KIRKLEES METROPOLITAN COUNCIL INVESTMENT & REGENERATION SERVICE

Reference No:	2023/62/90528/W
Site Address:	17, Roman Avenue, Mount, Huddersfield, HD3 3XP
Description:	Erection of detached outbuilding
Recommending Officer:	Luke Walstow

HOUSEHOLDER DELEGATED REPORT

**PROPOSED
FRONT ELEVATION**
SCALE 1:50

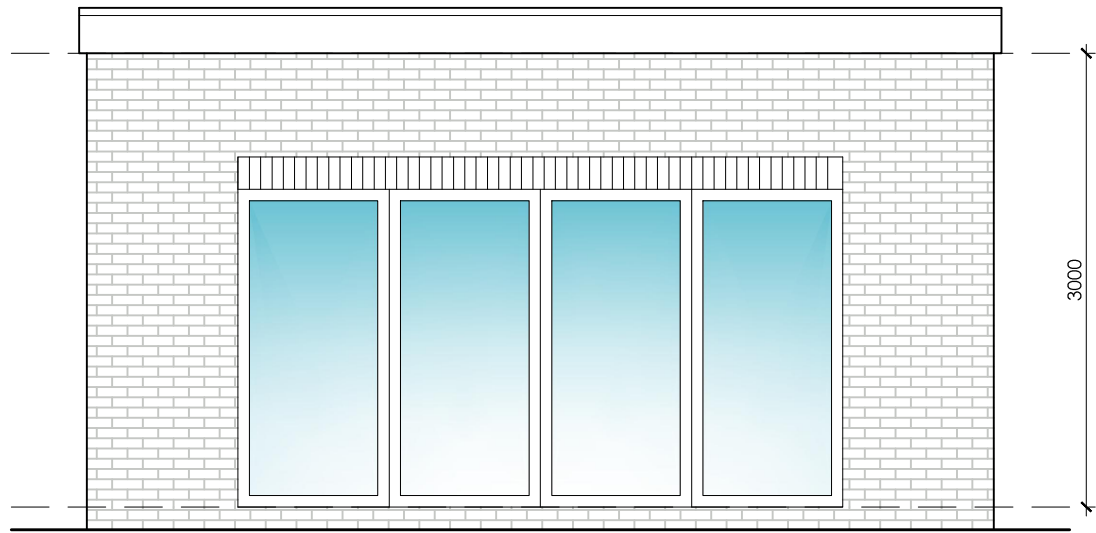
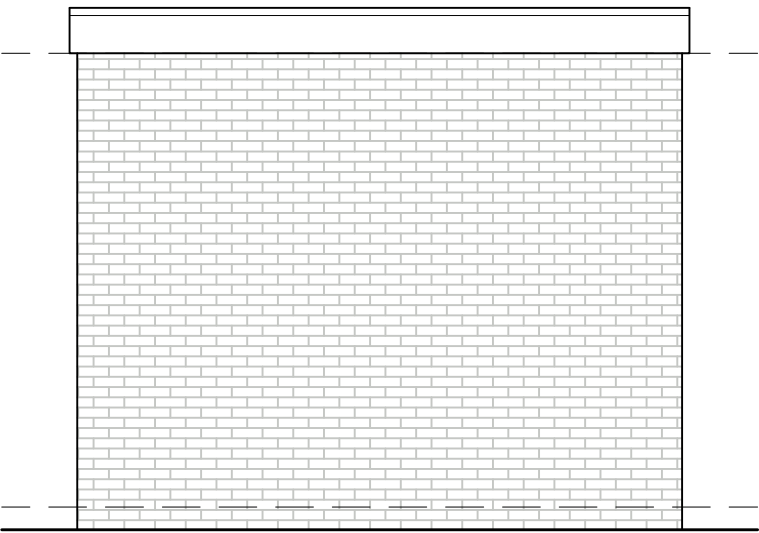
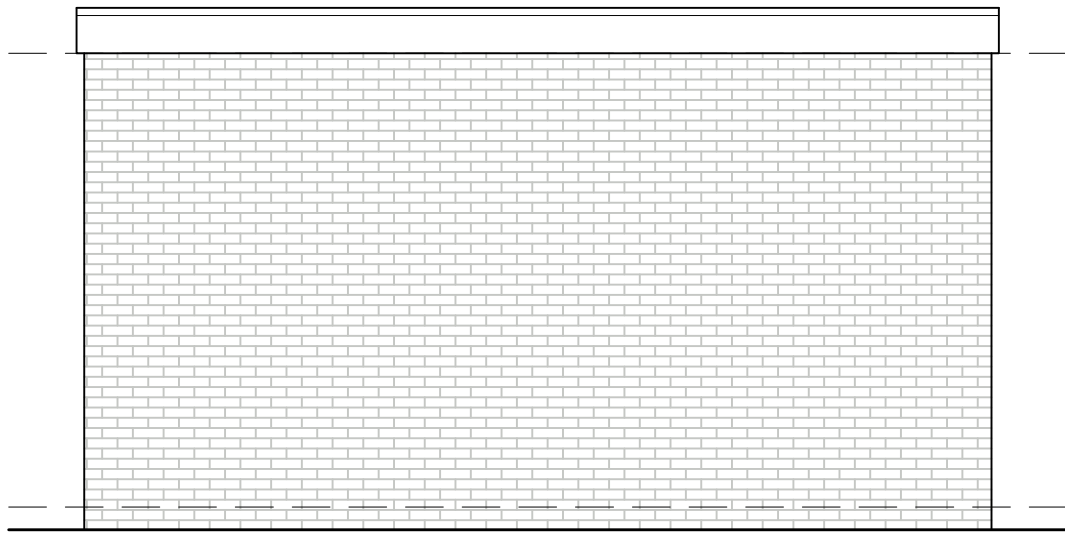
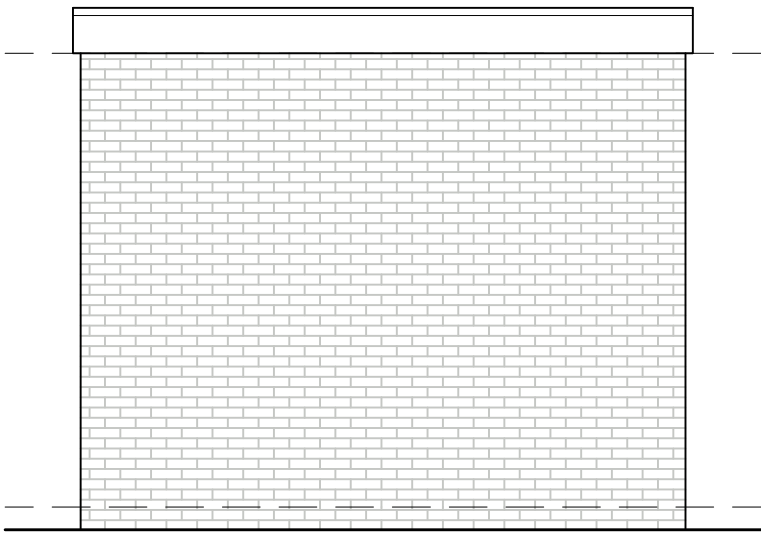
- 15 Roman Avenue – A semi-detached dwelling adjoined to the host dwelling to the west of the application site. The glazed front windows would be around 15m from the conservatory to the rear of this property, at an oblique angle. There is a ~1.3m close boarded fence with ~30cm trellis above forming the site boundary. There is also an outbuilding and mature shrubbery to elements of the boundary.

- 19 Roman Avenue – Semi-detached dwelling adjacent to the host dwelling to the east of the application site. Separated from the application site by ~1.8m close boarded fencing, tall mature hedging and an outbuilding in the application site and neighbouring back garden. Around 14m to the rear elevation of the property at an obstructed and oblique angle.

- 28 and 30 Mount Avenue – Semi-detached dwellings located to the rear (north) of the application site. Views of the building from both properties somewhat obscured by existing outbuildings and ~1.8m close boarded fencing. The submitted section indicates that the rear elevation of the building would be slightly dug into the site and would extend above the height of the existing fence by around ~1.2m.

Relevant key design principle (KDP) of the SPD, Policy in the Kirklees Local Plan and the NPPF	Further comments	✓ / X / N/A
Impact on privacy of neighbours (to sides, rear and front)	• KDP 3 & 4 of the SPD • Policy LP24 Design (d) (iv) • Chapter 12 of the NPPF	There are no proposed windows within the side and rear of the outbuilding which could impact the privacy of neighbours. Although there is a large element of glazing to the southern elevation, given the distance to the rear elevation of nos. 15 and 19 Roman Avenue, the presence of boundary treatments and outbuilding, it is concluded no material loss of privacy would ensue.	✓

Officer's liaised with the Agent regarding potential privacy screens and further information was submitted. This clarified that the door height is 2.1m, the existing boundary treatment is 1.6m high. "A privacy screen would need to be rather deep to stop a view from the bi-fold doors and, in turn not very attractive. A person of 6ft (1.8m) would not have much of the boundary to look over, therefore, I do not believe there would be a loss of privacy". Officer's concur with this conclusion.	
Impact on light and outlook of neighbours (to sides, rear and front)	• KDP 4, 5, 6 of the SPD • Policy LP24 Design (b) • Chapter 12 of the NPPF	Due to the location of outbuilding, a separation distance of at least ~11 metres to the closest neighbouring dwelling on Mount Avenue, the presence of close boarded fencing and the limited height of around 1.2m above this fence, it is concluded the outbuilding would not materially impact natural light received to neighbours' dwellings, recognising it is to the south of the properties on Mount Avenue. In addition, due to the outbuilding's siting, height and footprint, the outlook from neighbouring dwellings outlook would not be unduly impacted.	✓

SITE PLAN
SCALE 1:100

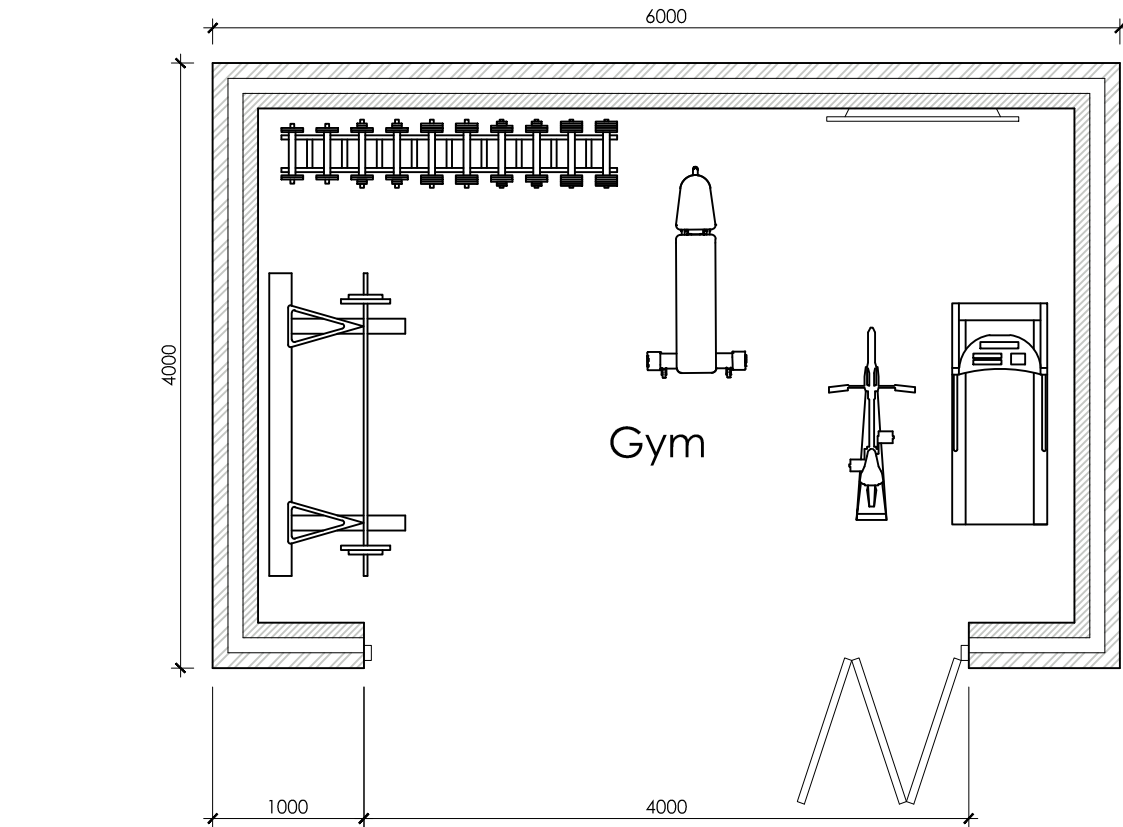
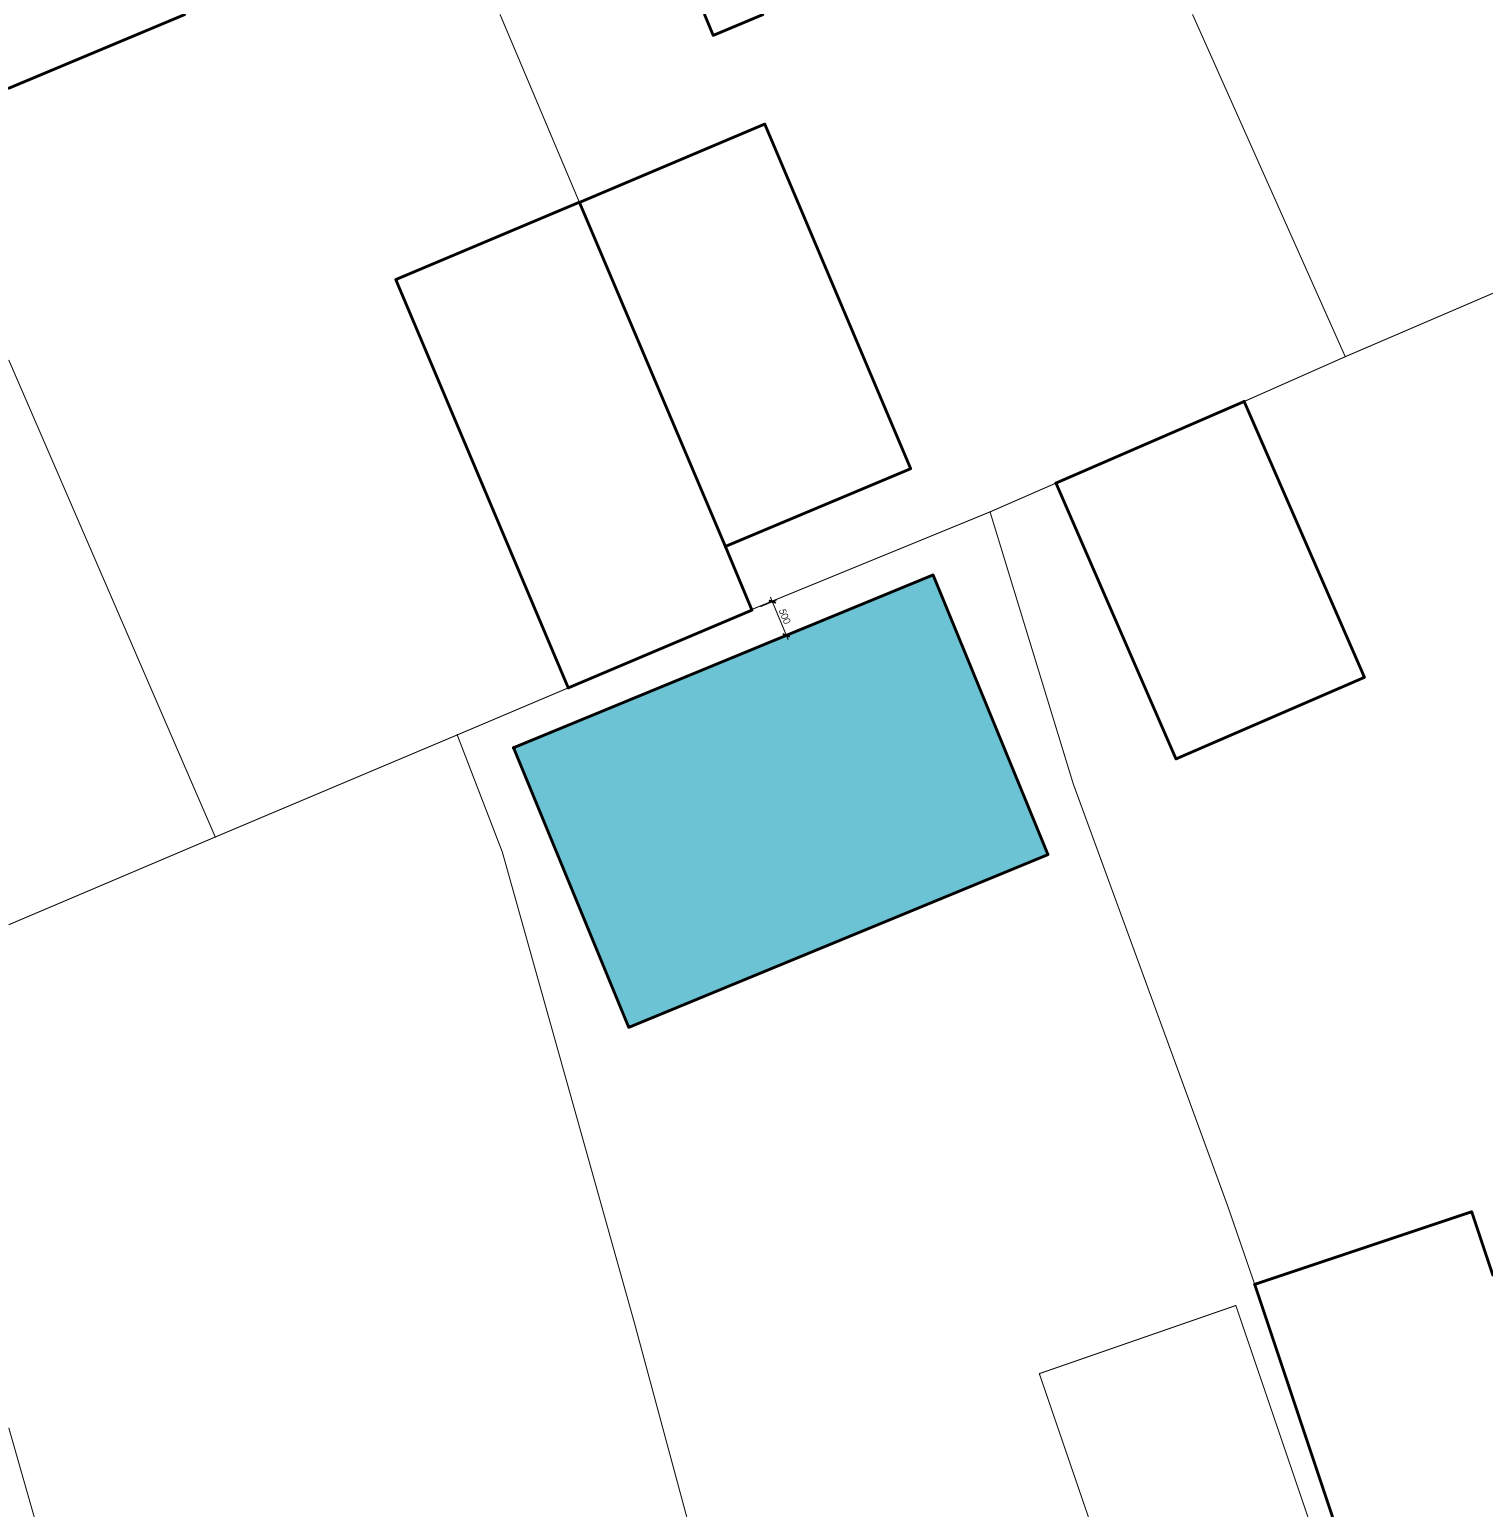
Relevant key design principle (KDP) of the SPD, Policy in the Kirklees Local Plan and the NPPF	Further comments	✓ / X / N/A
Impact on the Local character and street scene	• KDP1 of the SPD • Policy LP24 Design (a) and (c) of the KLP • Chapter 12 NPPF	Due to the location of the outbuilding being within the rear of the application site, the proposed development would have limited impact upon the street scene.	✓
Impact on original house	• KDP2 of the SPD • Policy LP24 Design (c) and (d) of the KLP • Chapter 12 of the NPPF	The proposed outbuilding would be located 19 metres from the original house and would have therefore would have a limited impact on the original structure.	✓
Height, scale and massing	• KDP 1 and 2 of the SPD • Policy LP24 Design (a), (c) and (d) of the KLP • Chapter 12 of the NPPF	The proposed height of the outbuilding would be 3.5m metres in total height. This height is considered to be acceptable, on balance, due to its positioning within the rear garden in relation to neighbouring dwellings, other outbuildings and boundary treatment. It would be 500mm from the rear boundaries and	✓

around ~1m from the side boundaries. The footprint of the outbuilding is considered to be acceptable in relation to the size of the rear garden.	
Facing materials and detailing	• KDP 9 of the SPD • Policy LP24 Design (d) (iii) of the KLP • Chapter 12 of the NPPF	The proposed external walls are to be constructed from brick which match the host dwelling. The materials are considered to be acceptable in design.	✓
Roof style	• KDP 1 and 2 of the SPD • Policy LP24 Design (a), (c) and (d) of the KLP • Chapter 12 of the NPPF	The outbuilding is proposed to have a flat roof which would keep in character of existing outbuildings within neighbouring properties rear gardens, which is considered to be acceptable.	✓
Window proportions	• KDP 1 and 2 of the SPD • Policy LP24 Design (a), (c) and (d) of the KLP • Chapter 12 of the NPPF	4 glazed panels are proposed along the front elevation of the outbuilding. The glazed panels also act as doors. The proposed glazed aspects of the outbuilding are considered to be acceptable. There are no windows within side or rear external walls which could impact neighbouring dwellings residential amenity.	✓

Relevant key design principle (KDP) of the SPD, Policy in the Kirklees Local Plan and the NPPF	Further comments	✓ / X / N/A
Impact on trees	• KDP 13 of the SPD • Policy LP24 Design (d) (i) (iv) Policy LP33 Trees • Chapter 12 of the NPPF	Officers noted an existing tree located to the rear of the site where the proposed outbuilding would be erected during the site visit. Because of this, KC Trees was consulted but the tree has since been felled. As this was not formally protected by TPO, there were no protections in place which required the retention of the tree.	✓
Impact on ecology	• KDP 12 of the SPD • Policy LP30 • Chapter 15 of the NPPF	N/A – tree removed.	✓
Carbon Budget / Climate change statement	• KDP 8, 9, 10 & 11 of the SPD • Policy LP51 • Chapter 14 of the NPPF	Small scale domestic development to an existing dwelling. As such, no special measures required in terms of the planning application with regards to carbon emissions. A Climate Change Statement has been submitted with this application.	✓
